SPACE VILLAGE FILING NO. 4
 A PORTION OF THE NW 1/4 OF SEC. 17, T14S,
 R65W, OF THE 6th P.M., EL PASO COUNTY, COLORADO
 DEVELOPMENT PLAN

**SPACE VILLAGE FILING NO. 4
 EL PASO COUNTY, CO**

COVER SHEET

SHEET TITLE:
COVER SHEET

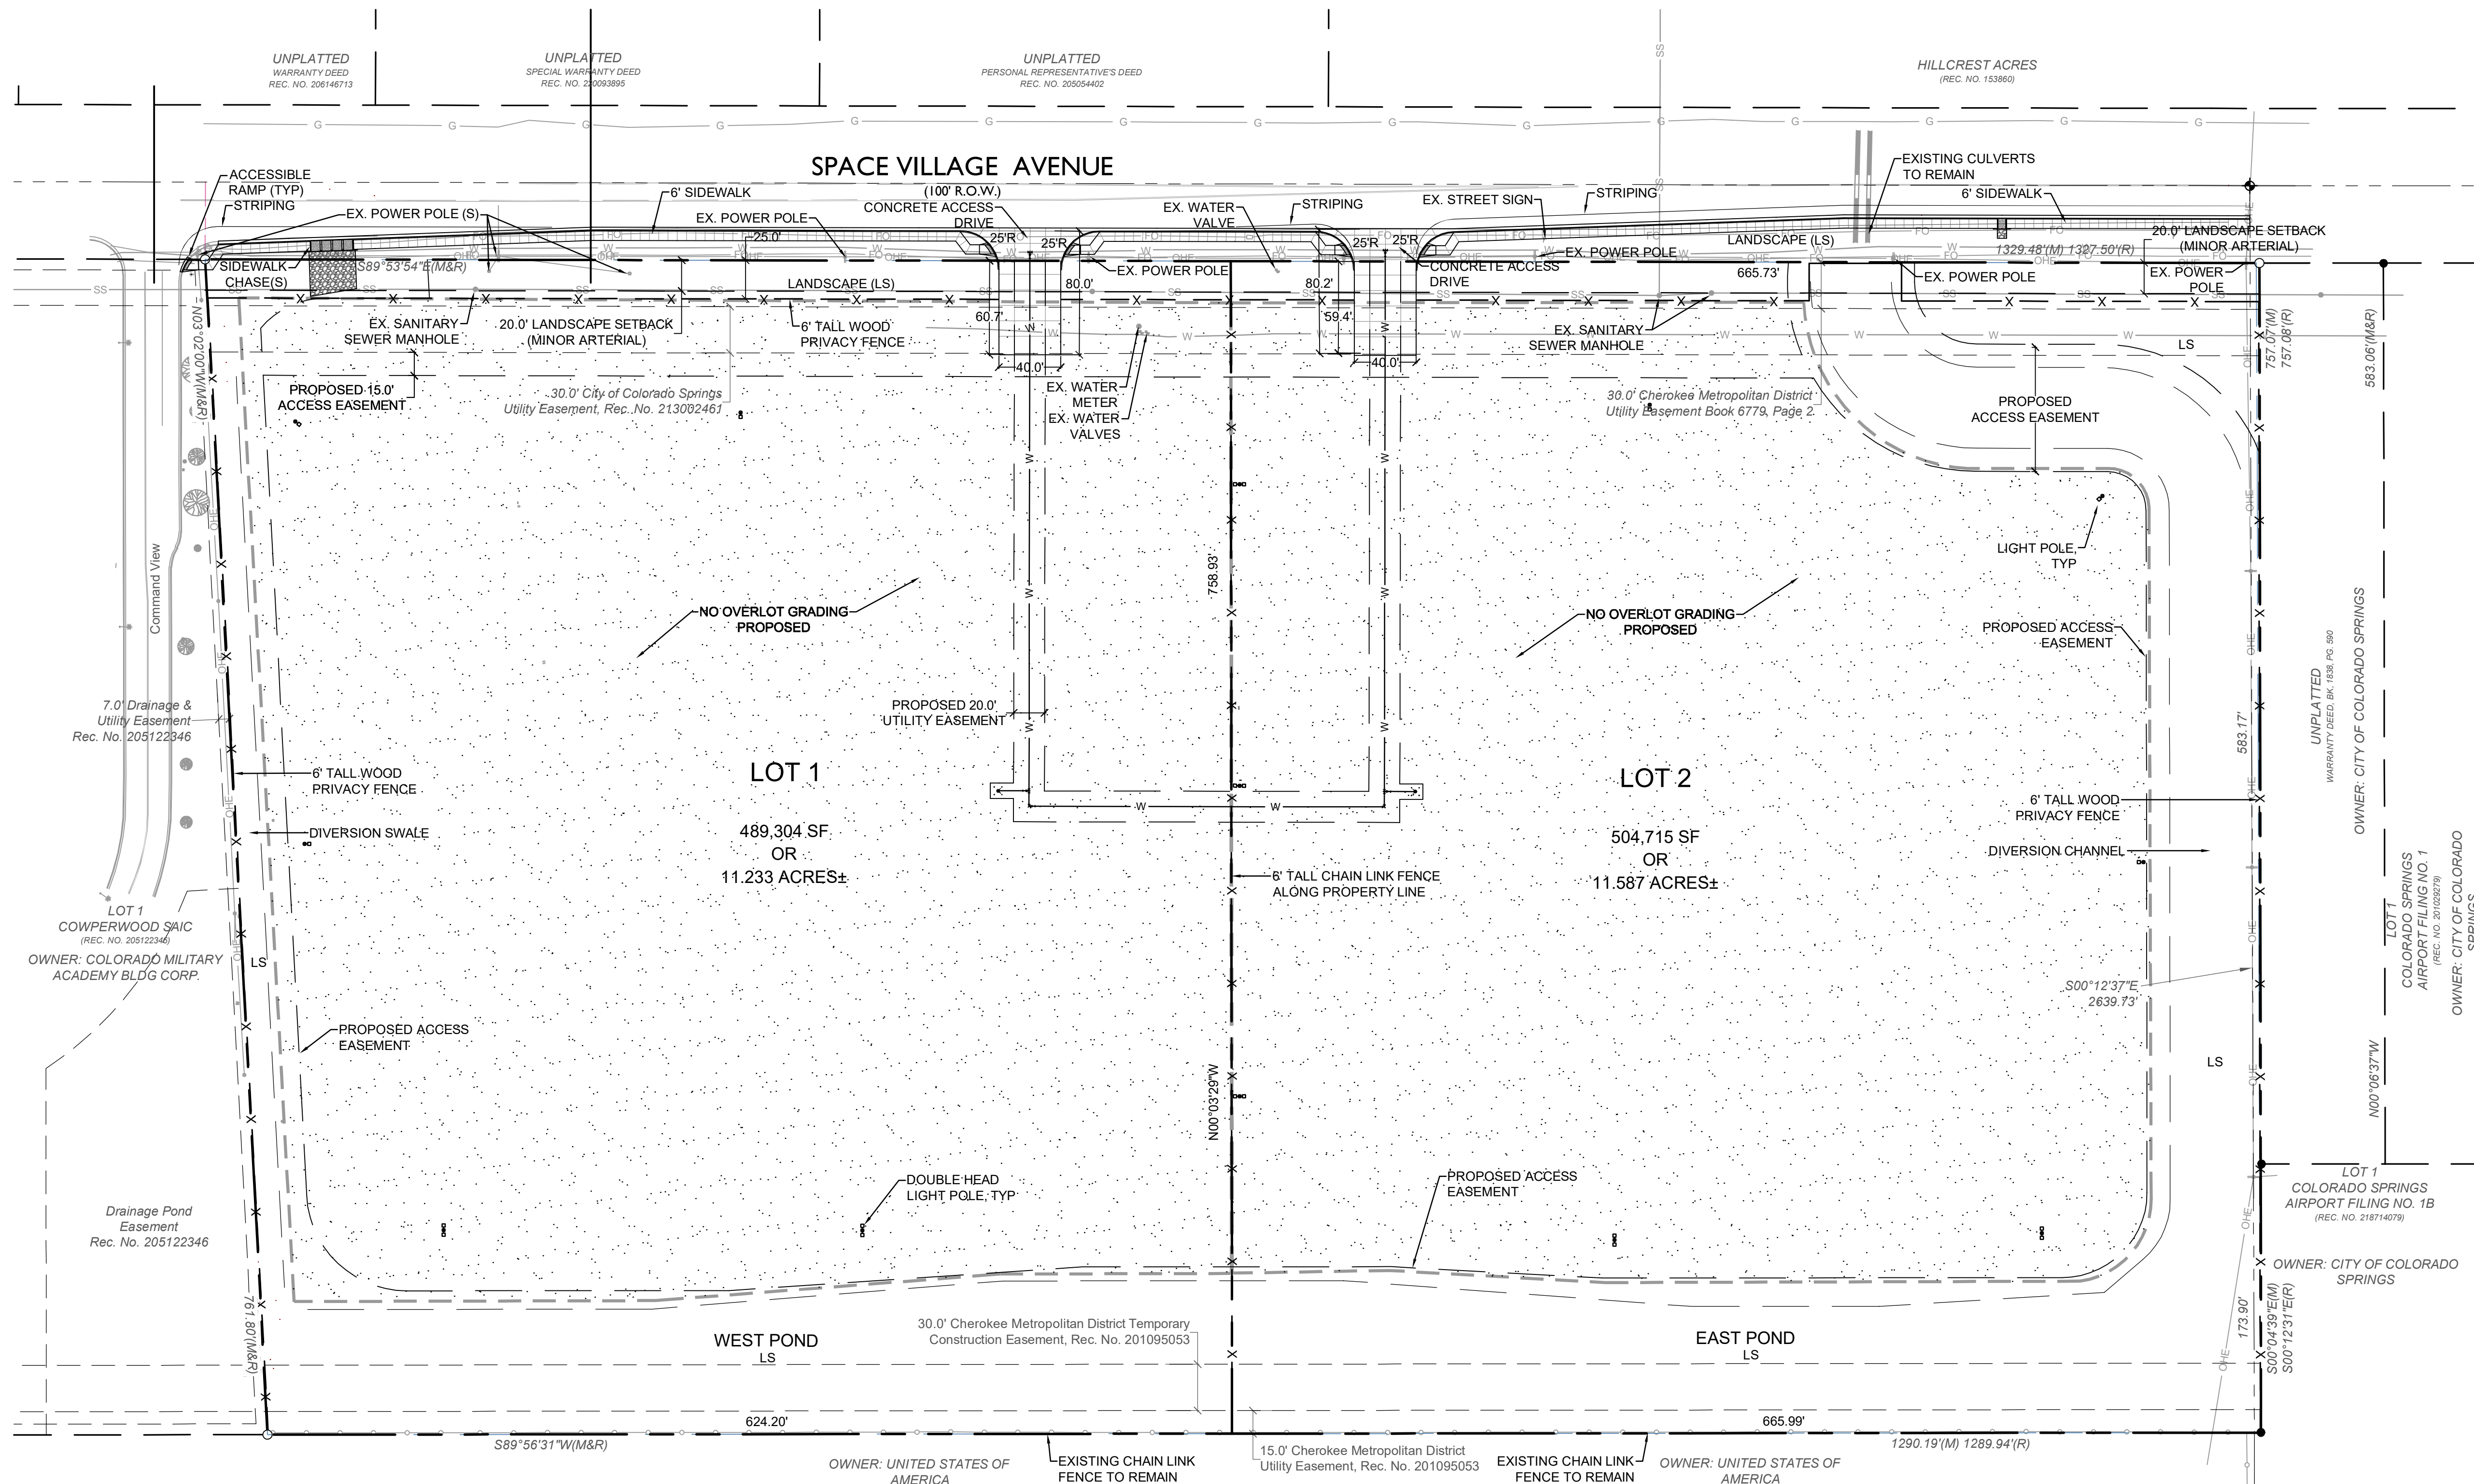
Unresolved Review 1
 Comment:
 - Update to 719-520-6300

Unresolved Review 1 Comment:
 - Remove and replace with
 Ashlyn Mathy

Unresolved Review 1 Comment:
 - Add PCD Director's Signature Block.

Unresolved Review 1 Comment:
 - Provide Floodplain Zoning

Please add:
 Unresolved from v1

- Lot area coverage calculation
- Existing/proposed land use and zoning
- Total gross building square footage
- Open space, landscaping, and impermeable surface percentage

Unresolved Review 1 Comment:
 - Revise sheet numbers after removing
 "Preliminary Grading Sheet"

Unresolved Review 1 Comment:
 - Add "PCD File No. PPR-23-003"

SHEET TITLE: SITE PLAN

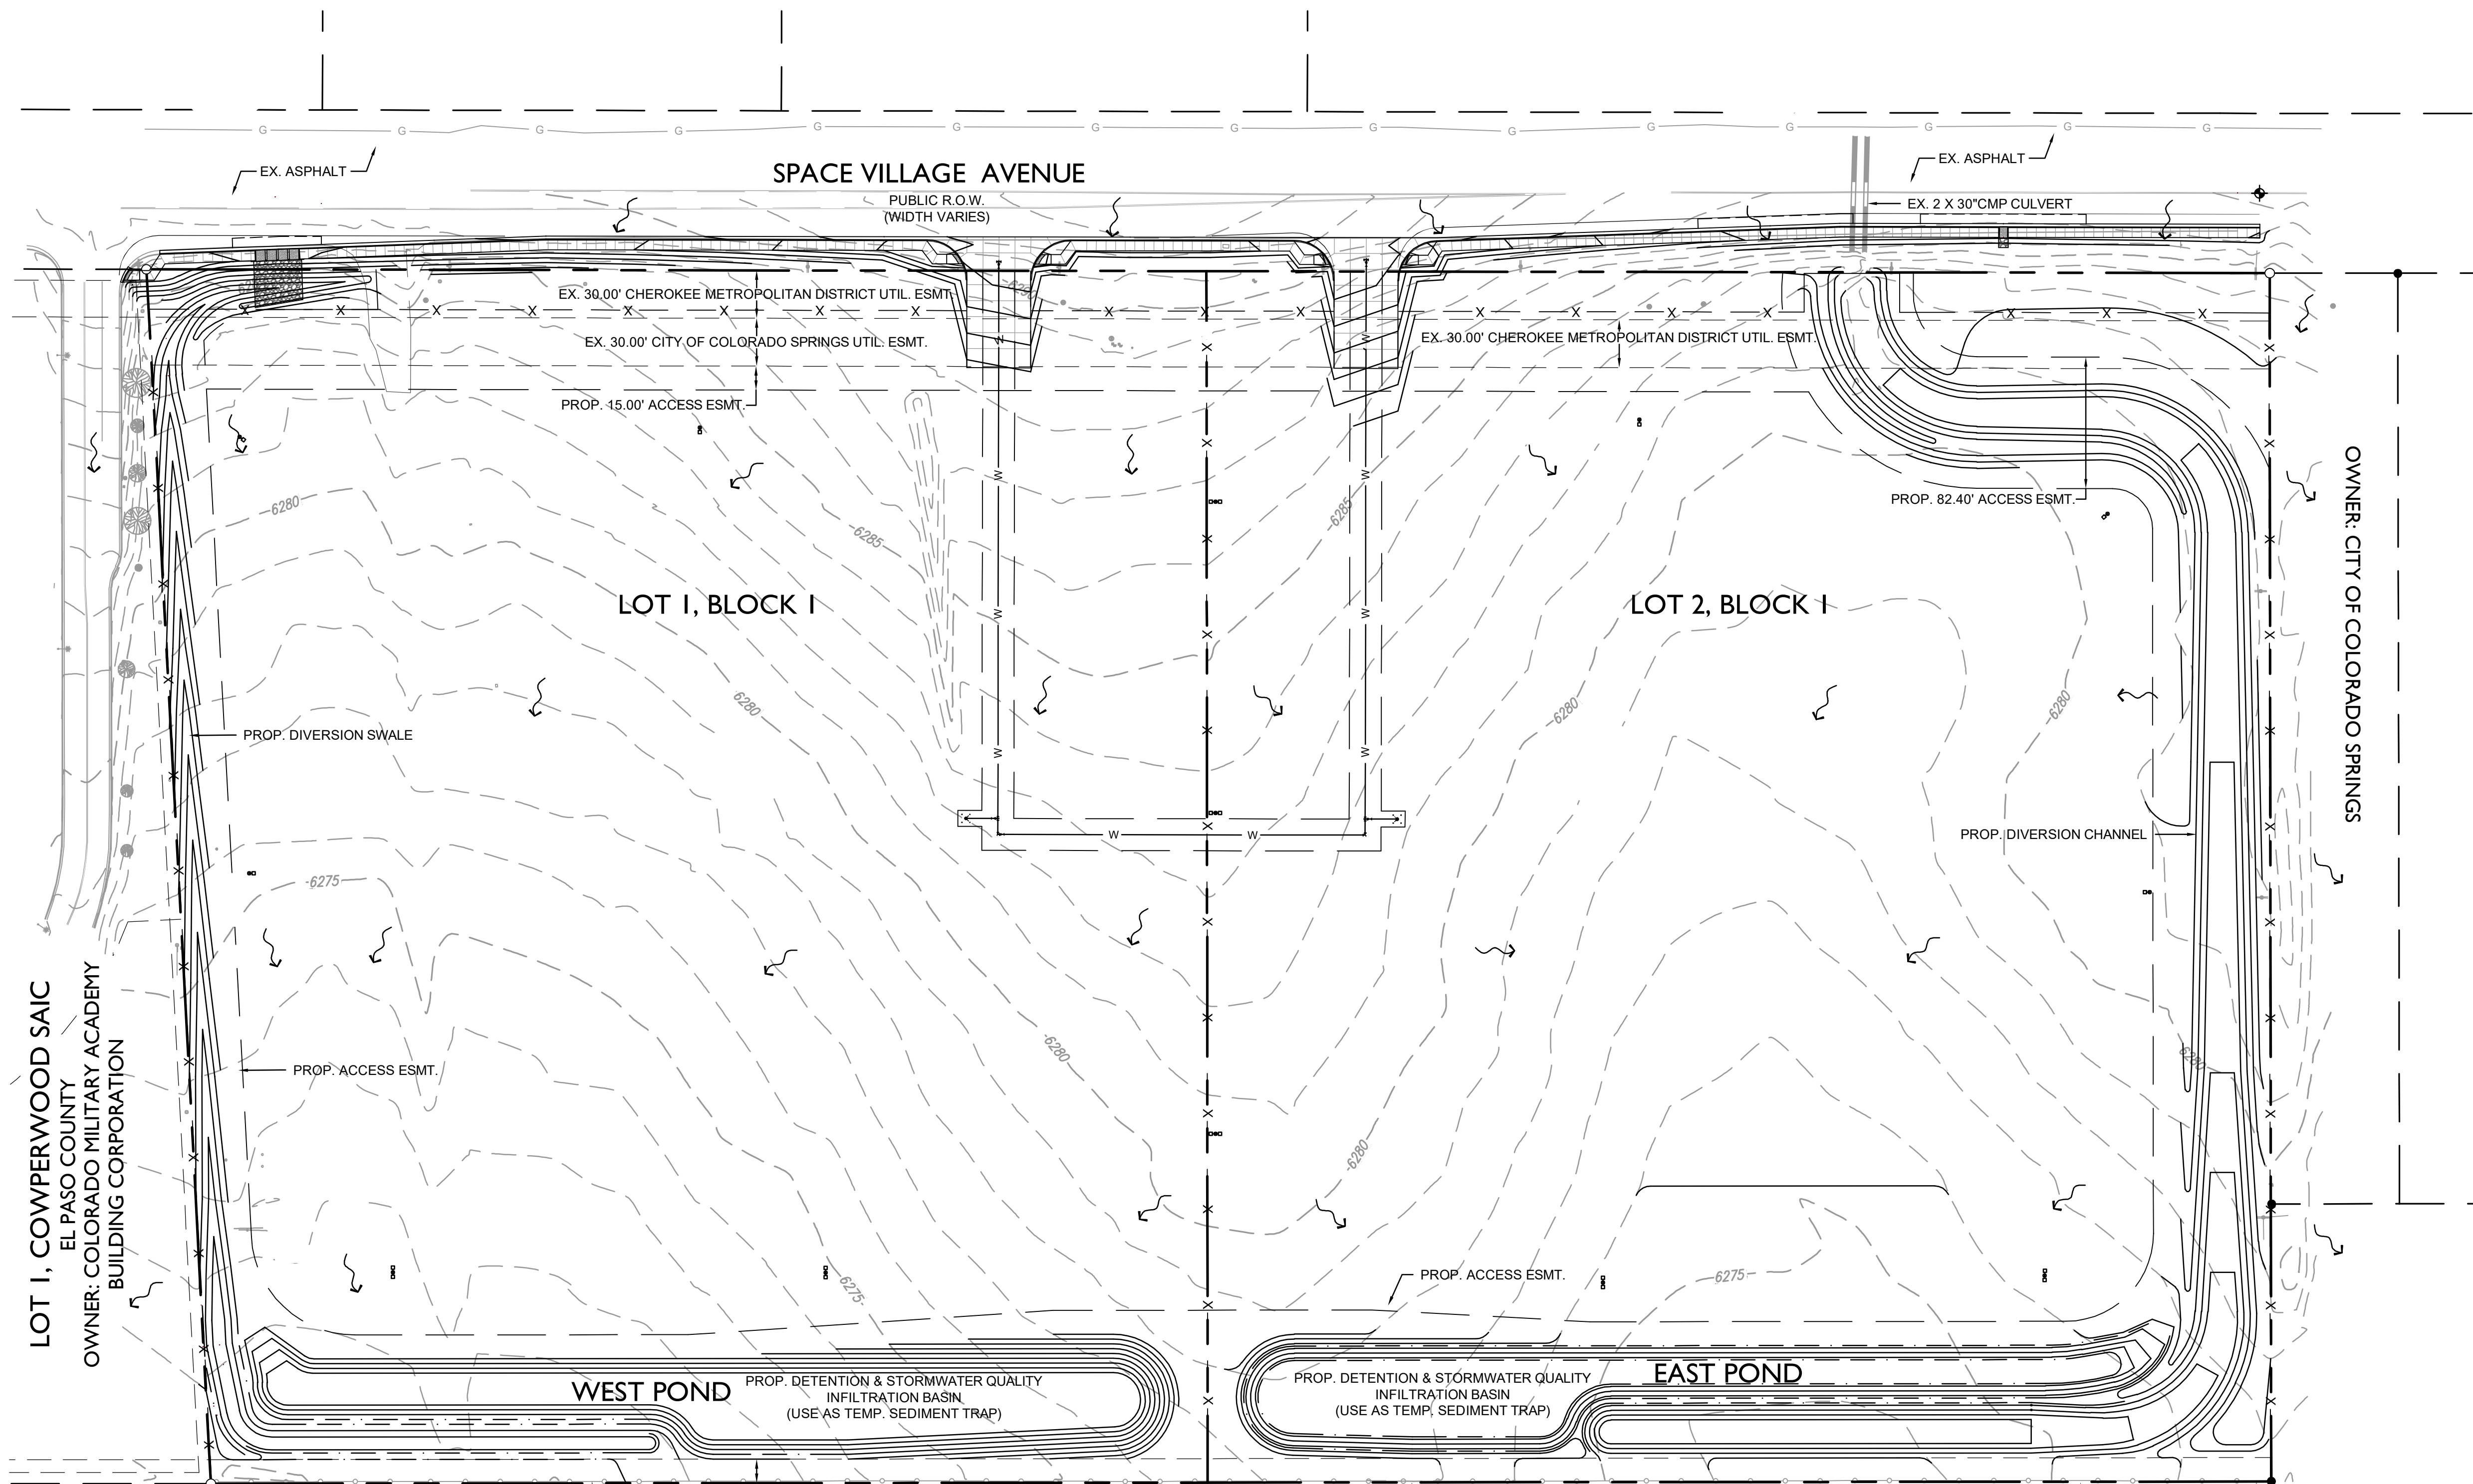
Please refer to GEC Plan in MS227 and update the site development plan accordingly.

See comments provided on the GEC Plan in MS227 regarding the recommended alignment from CDOT of the eastern driveway with the driveway on the opposite side of Space Village Avenue.

Unresolved Review 1 Comment: - Add label for drainage easement locations.

Please include: UNRESOLVED V1 (if none, then specify)

- Traffic circulation on site including all points of ingress/egress into the property
- The layout and location of all off-street parking, loading and other vehicular use areas, unless otherwise depicted in detail on a separate parking plan. If depicted on a separate parking plan then depiction of the parking areas are required.
- Location of all no-build areas, floodplain, drainageways and facilities
- Location of all garbage receptacles with a graphical depiction of the screening mechanism
